From: wilpshire parish council <wilpshireparishcouncil@gmail.com>
Sent: 11 September 2018 07:31
To: planning; wilpshire parish council
Subject: 3/2018/0723 Pyethorn 150 Whalley Road Wilpshire Comments from Wilpshire Parish Council

3/2018/0723 Pyethorn 150 Whalley Road Wilpshire

Title:
TREE CONSTRAINTS PLAN
 In Relation to Proposed Construction of Detached Residential Property

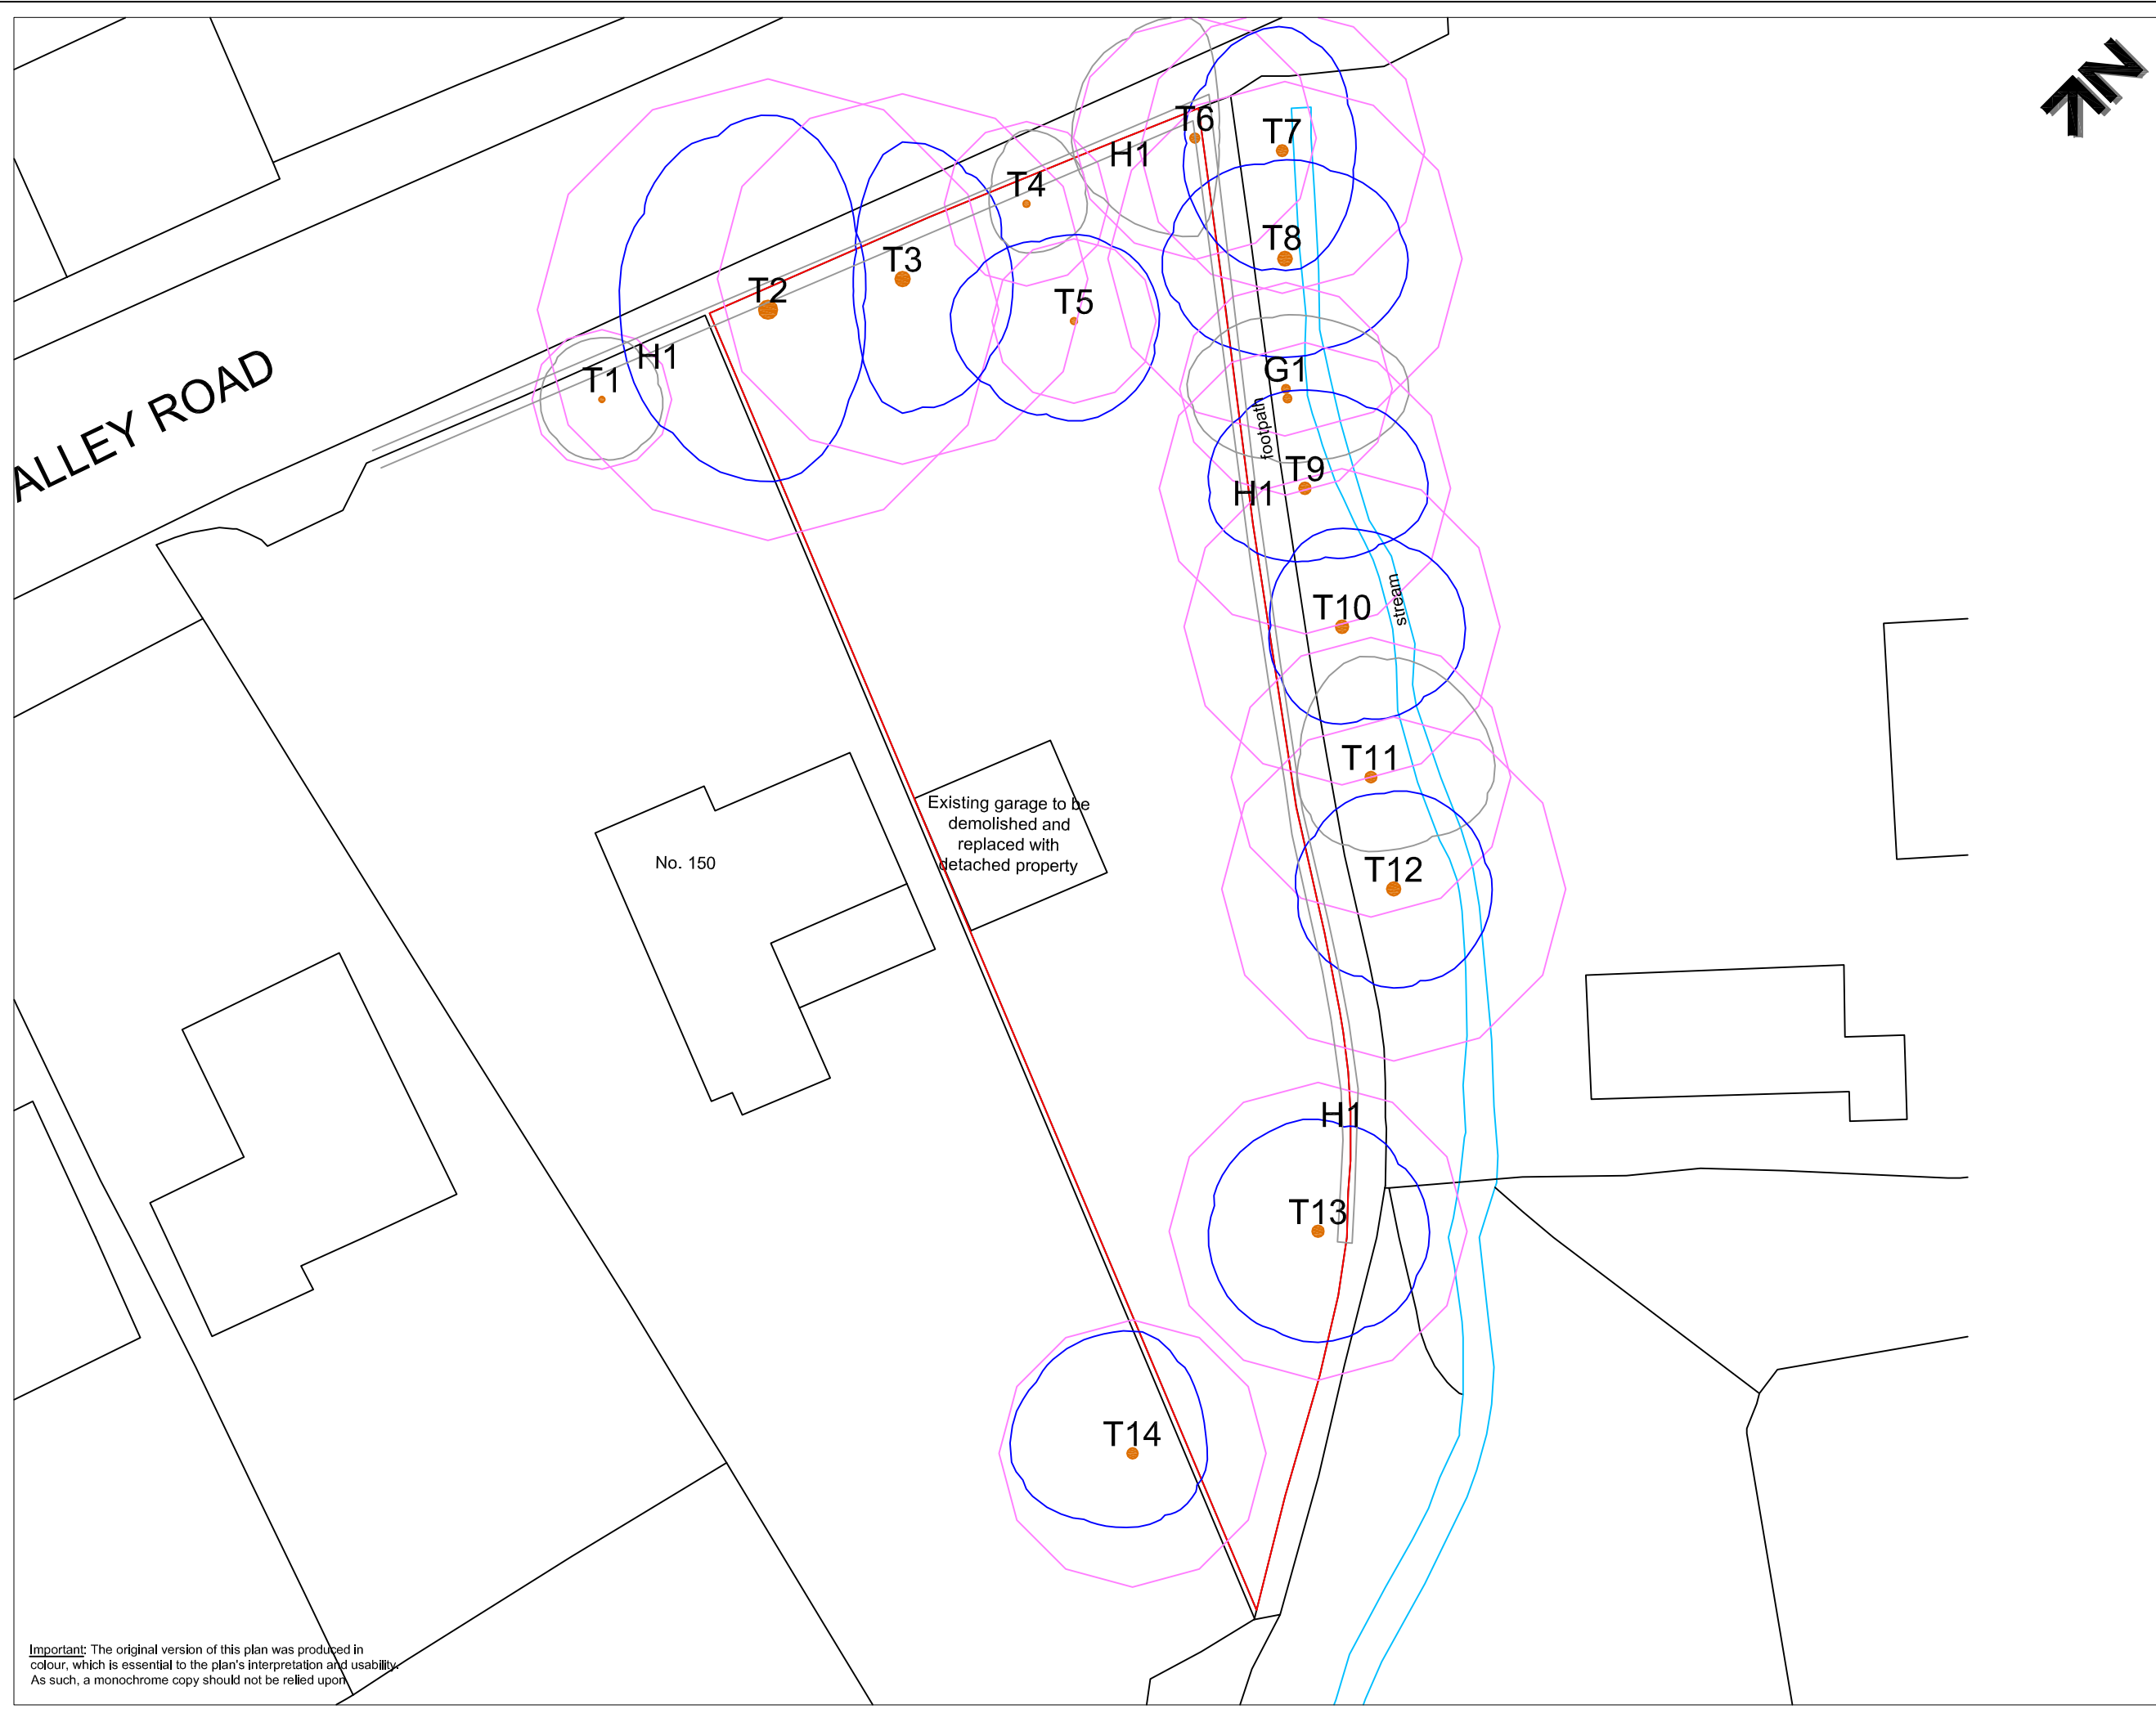
if a 2 storey dwelling were to be built on the footprint of garage the closeness of the properties would be out of character in the area. The loss of hedging to the road would affect street scene. Concern is also expressed regarding the trees along the frontage and if any of these were lost it would detract from the present street scene.
